Subject: Response to Submission, St Anthony of Padua Catholic School MOD 1, 125-165 Tenth Avenue and 140-170 Eleventh Avenue, Austral (SSD 8865)

Thank you for your e-mail received 22 October 2021, requesting comments on response to submissions for the above proposal. Environment, Energy and Science Group (EES) has reviewed the additional information provided including amended architectural plans and updated flood assessment and provides the below comments.

LANDSCAPE MASTER PLAN

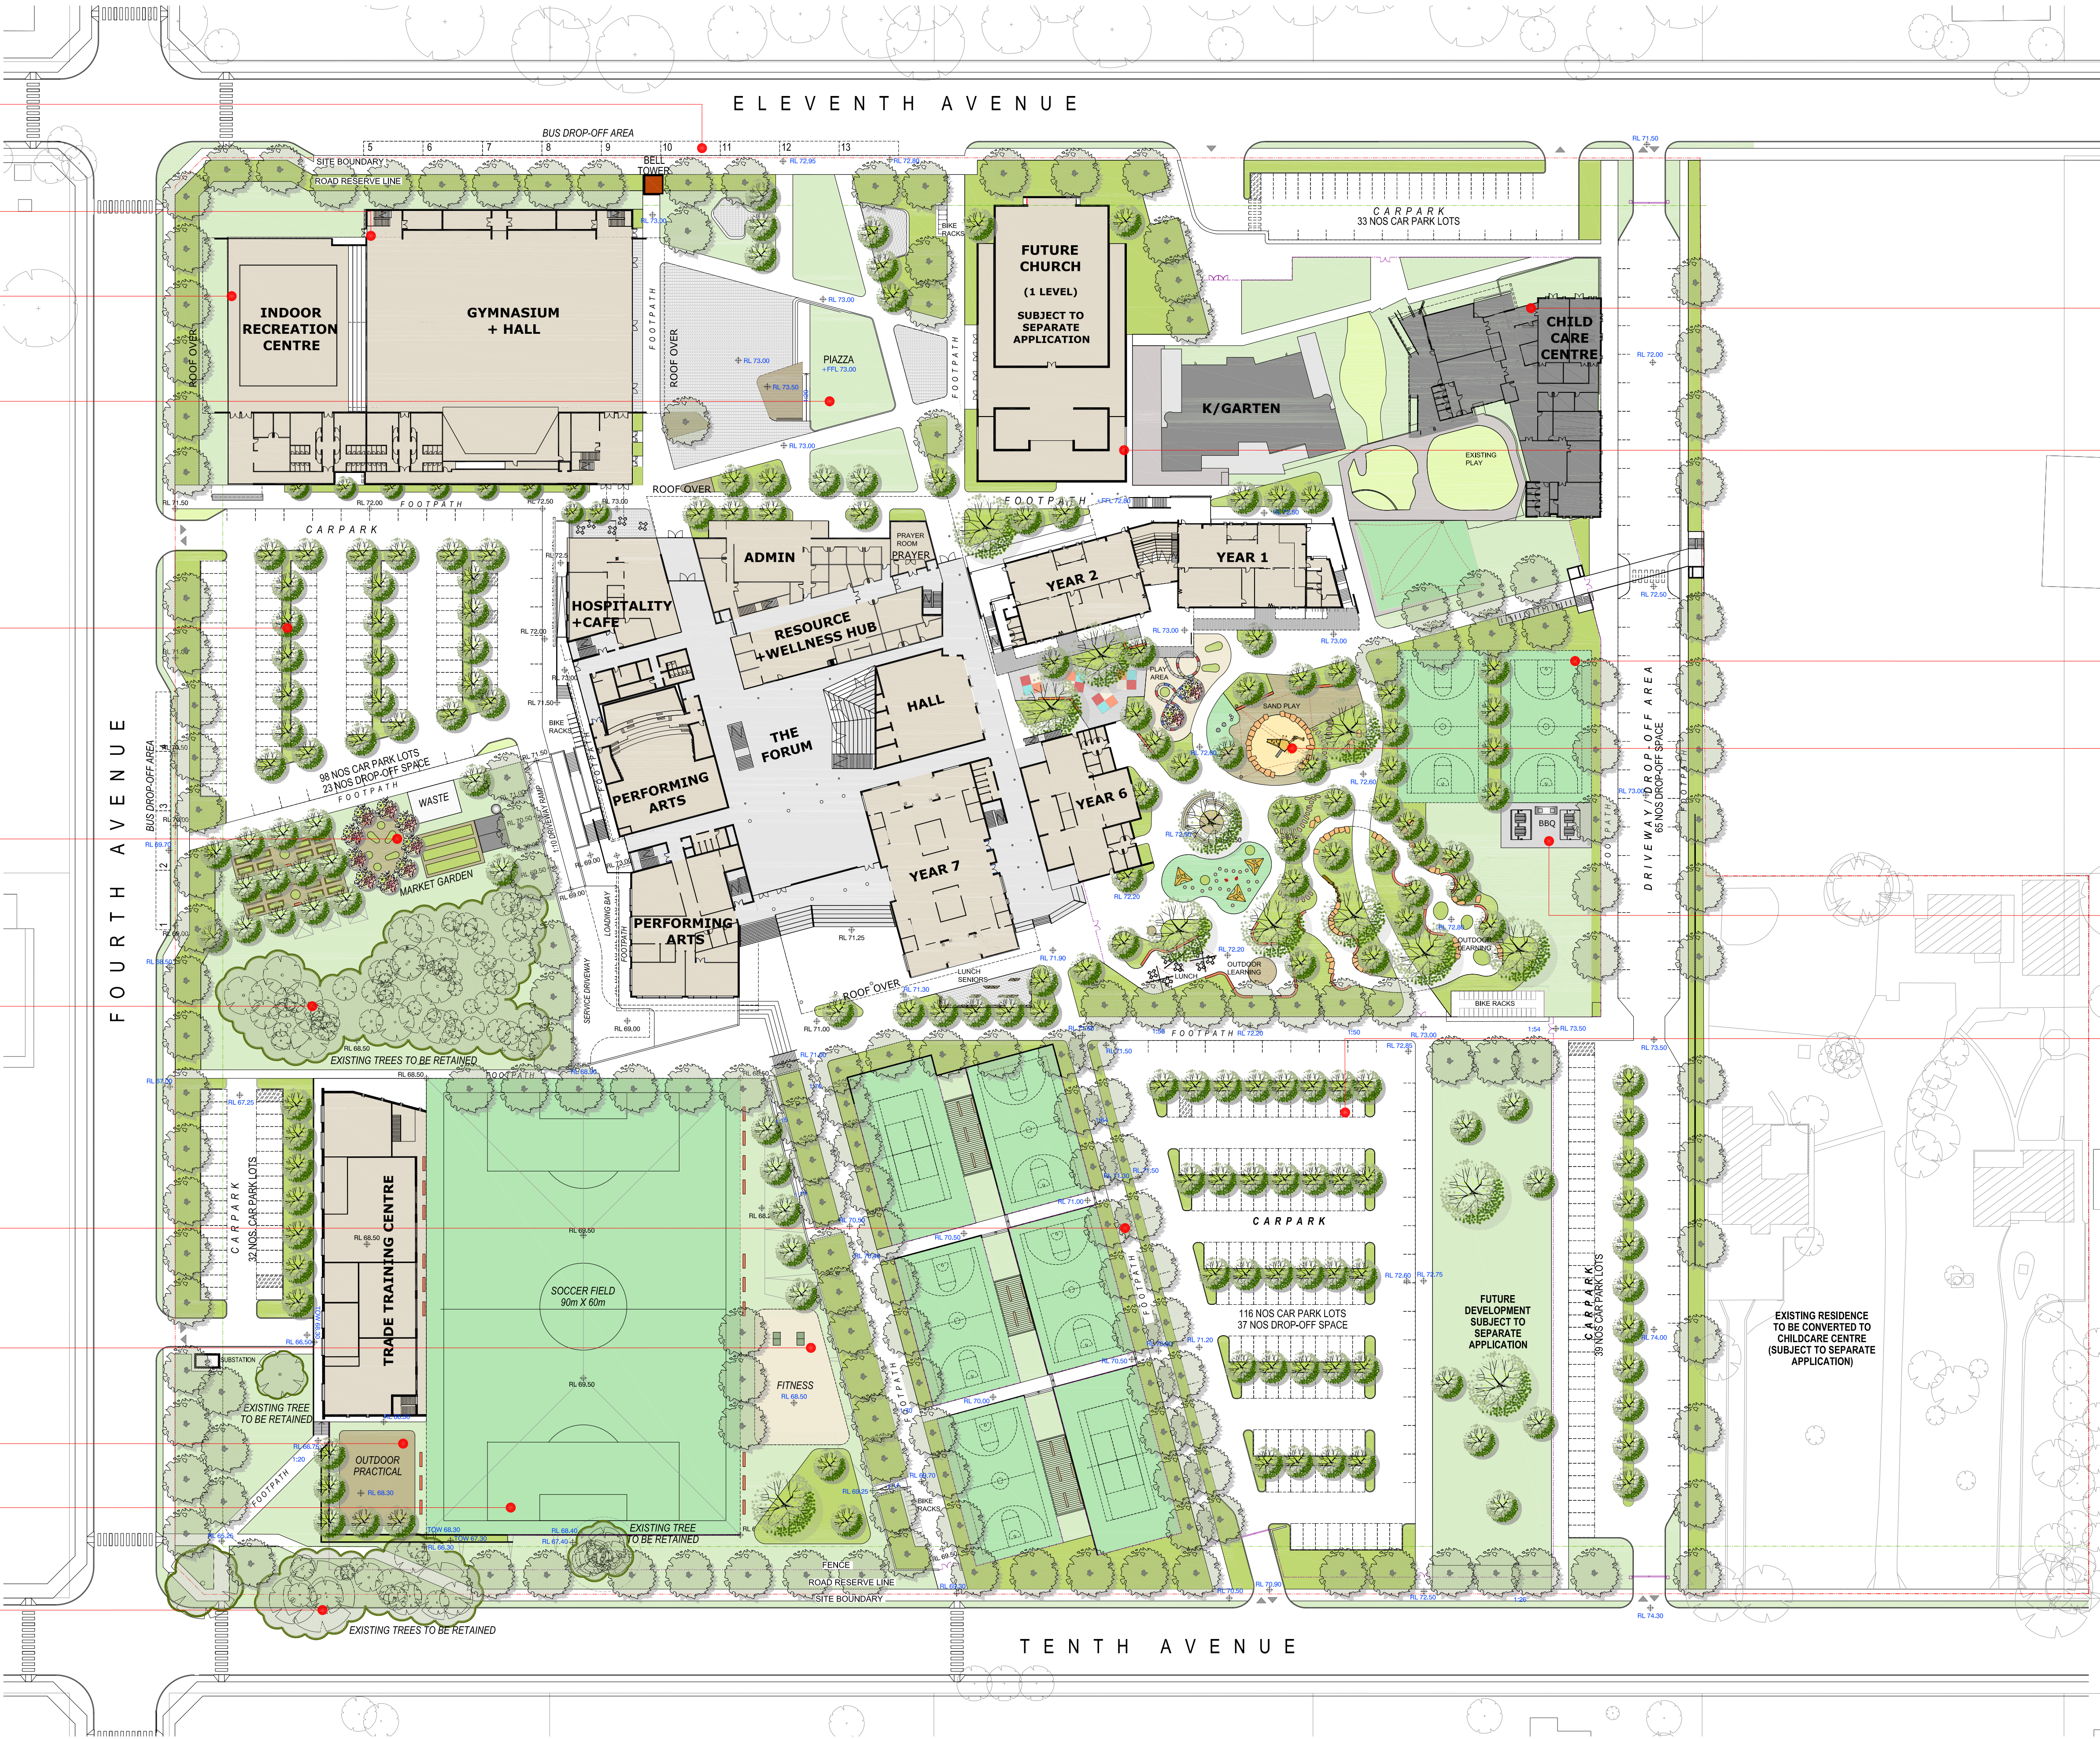
The landscape plan also includes a remnant patch of CPW for retention and protection. A condition of approval should be applied that only locally native CPW species are to be utilised for landscape planting within this remnant patch and that any landscape works should be undertaken under the supervision of a suitable qualified bush regenerator or ecologist.

Further to the above, EES notes that the modified proposal presents greater potential for encroachment into the tree protection zones within the remnant patch of CPW. For example, the modified plans show potential 1:4 batter from the proposed sports field adjacent to the patch and a new pathway through the patch. To protect this remnant patch of CPW, a condition of consent should be applied for a suitably qualified arborist (Diploma in Arboriculture) to establish tree protection fencing in accordance with Australian Standard 4970:2009 Protection of Trees on Development Sites prior to any works commencing on site. No encroachment greater than 10% of the tree protection zone is to occur without prior confirmation from the project arborist that this can occur without adverse impacts to trees.
